# Markup Summary

DRAINAGE, GRADING & EROSION CONTROL COVER

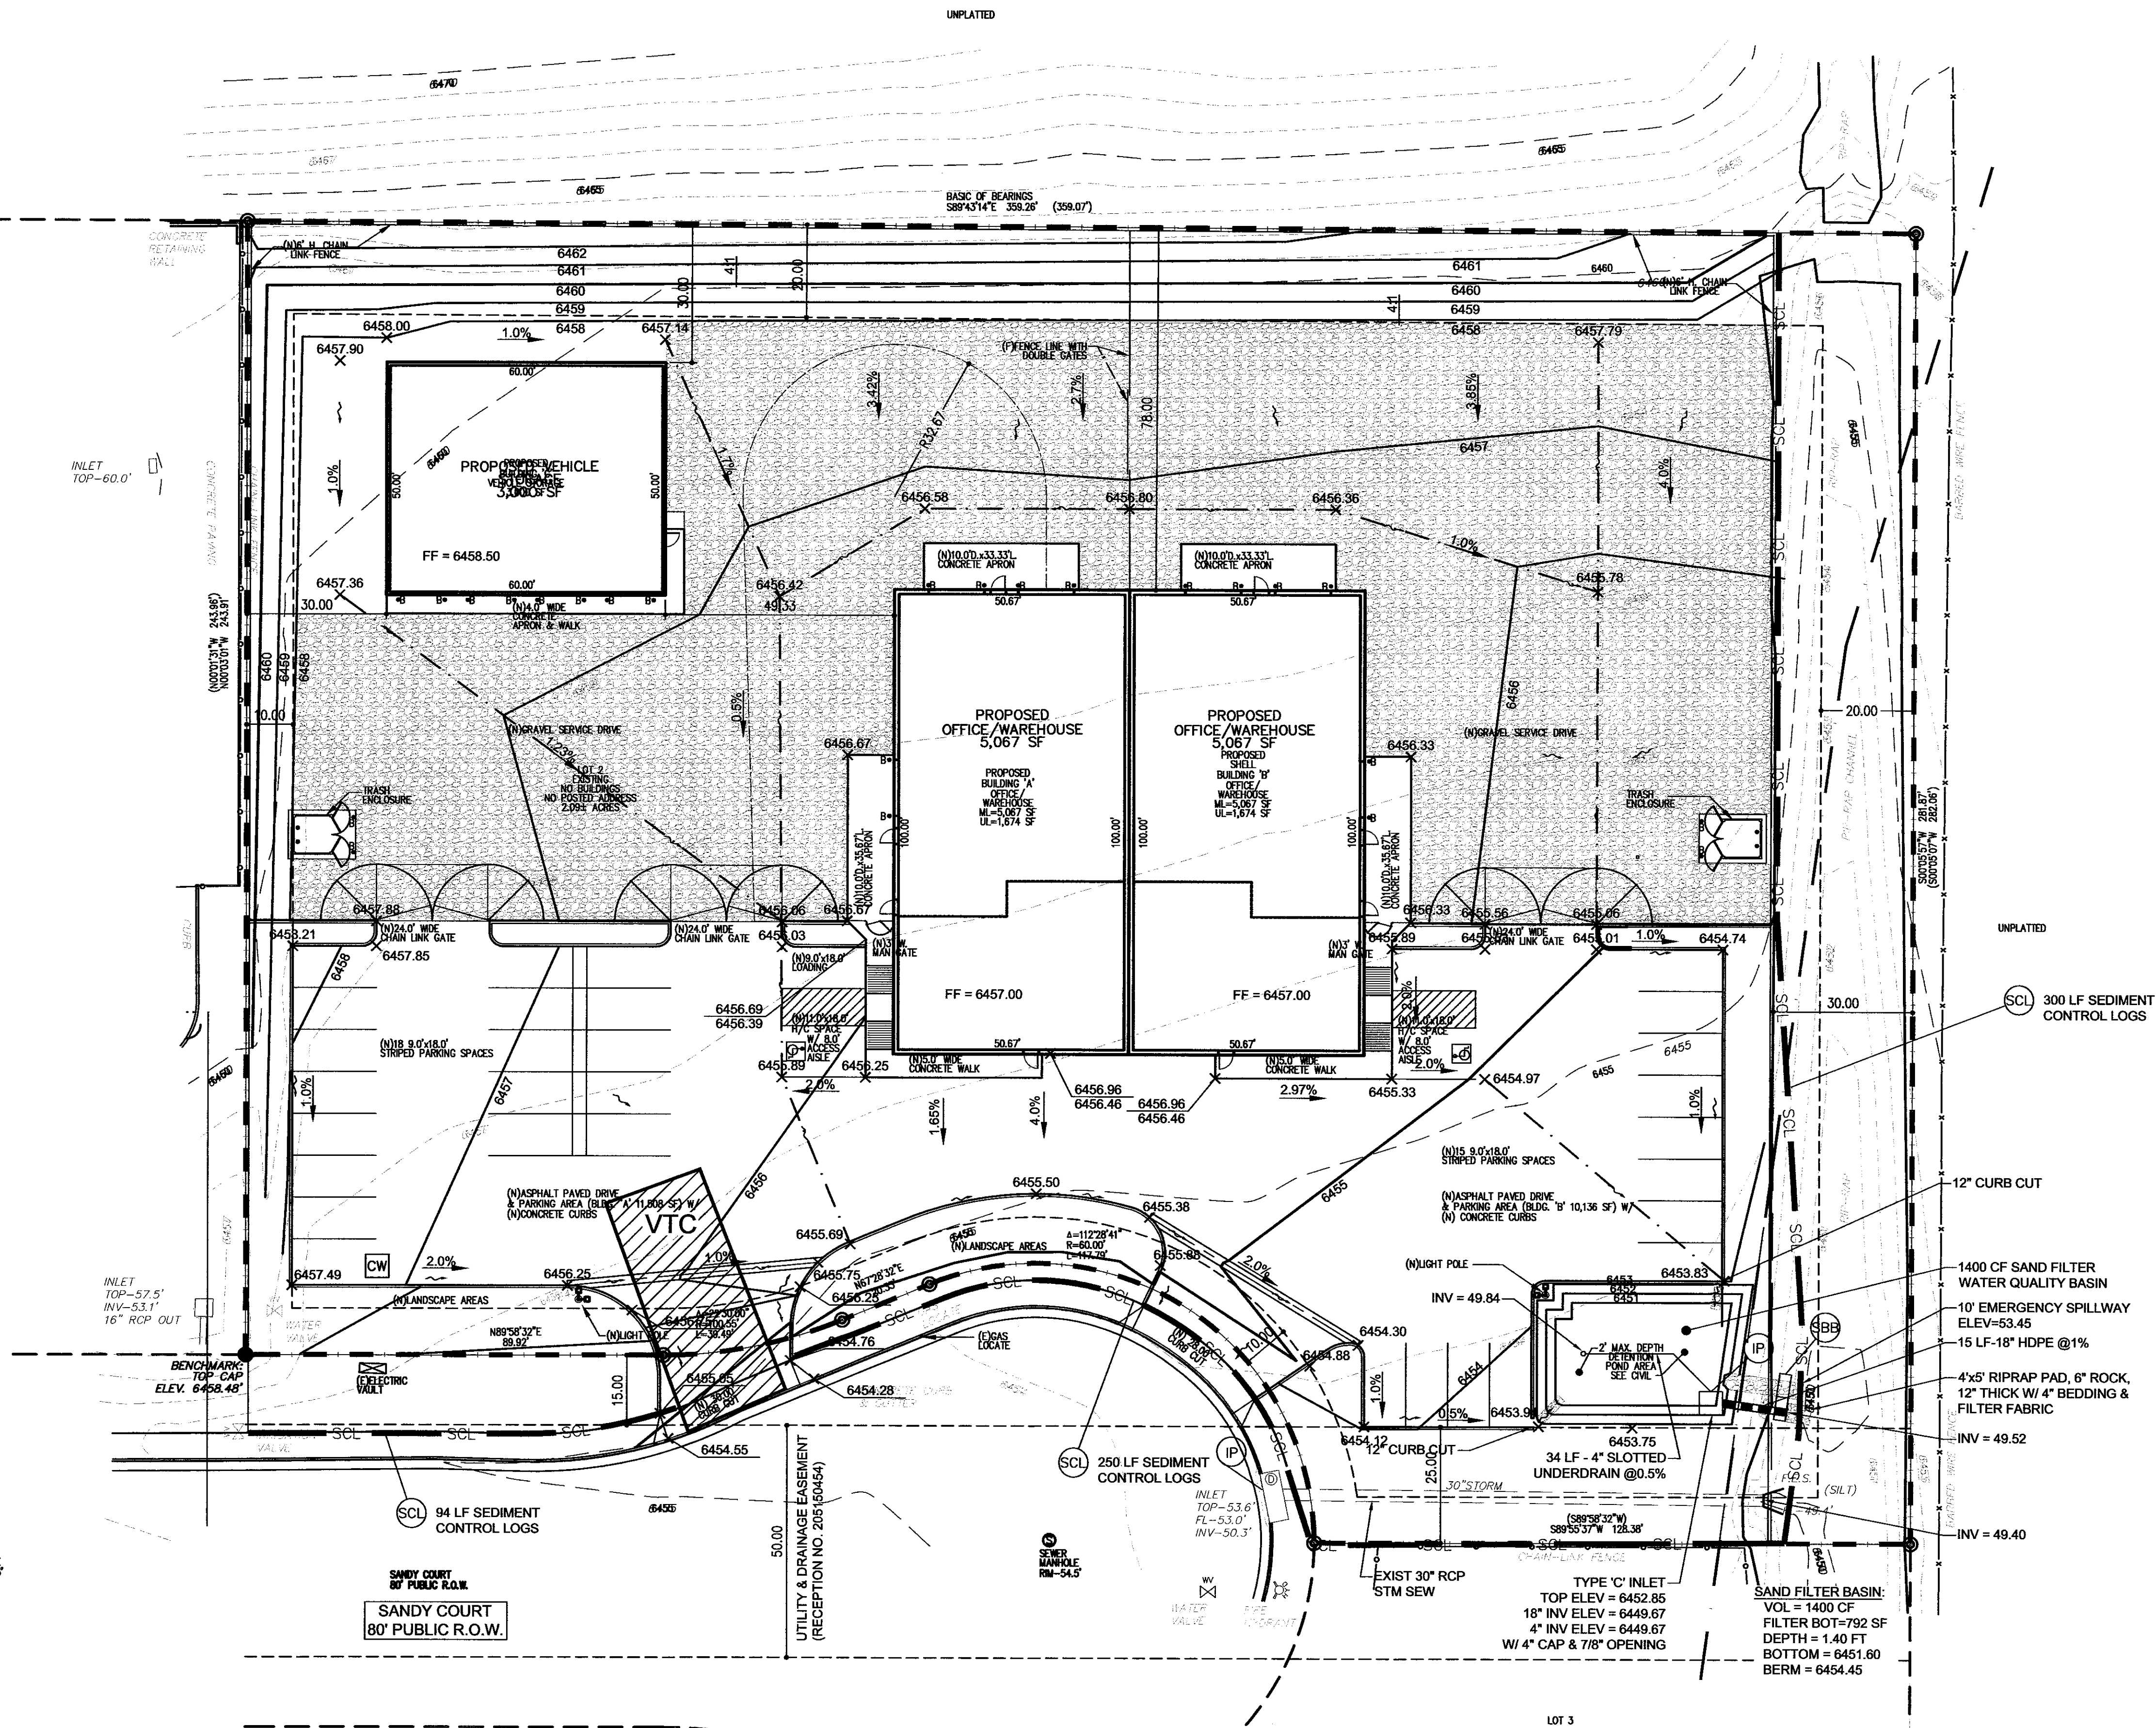
Update the elevations to match the GEC plan.

label the crest elevation

Invert

Include this sheet as part of the stand alone grading and erosion control plan set.

label the filter bed elevation
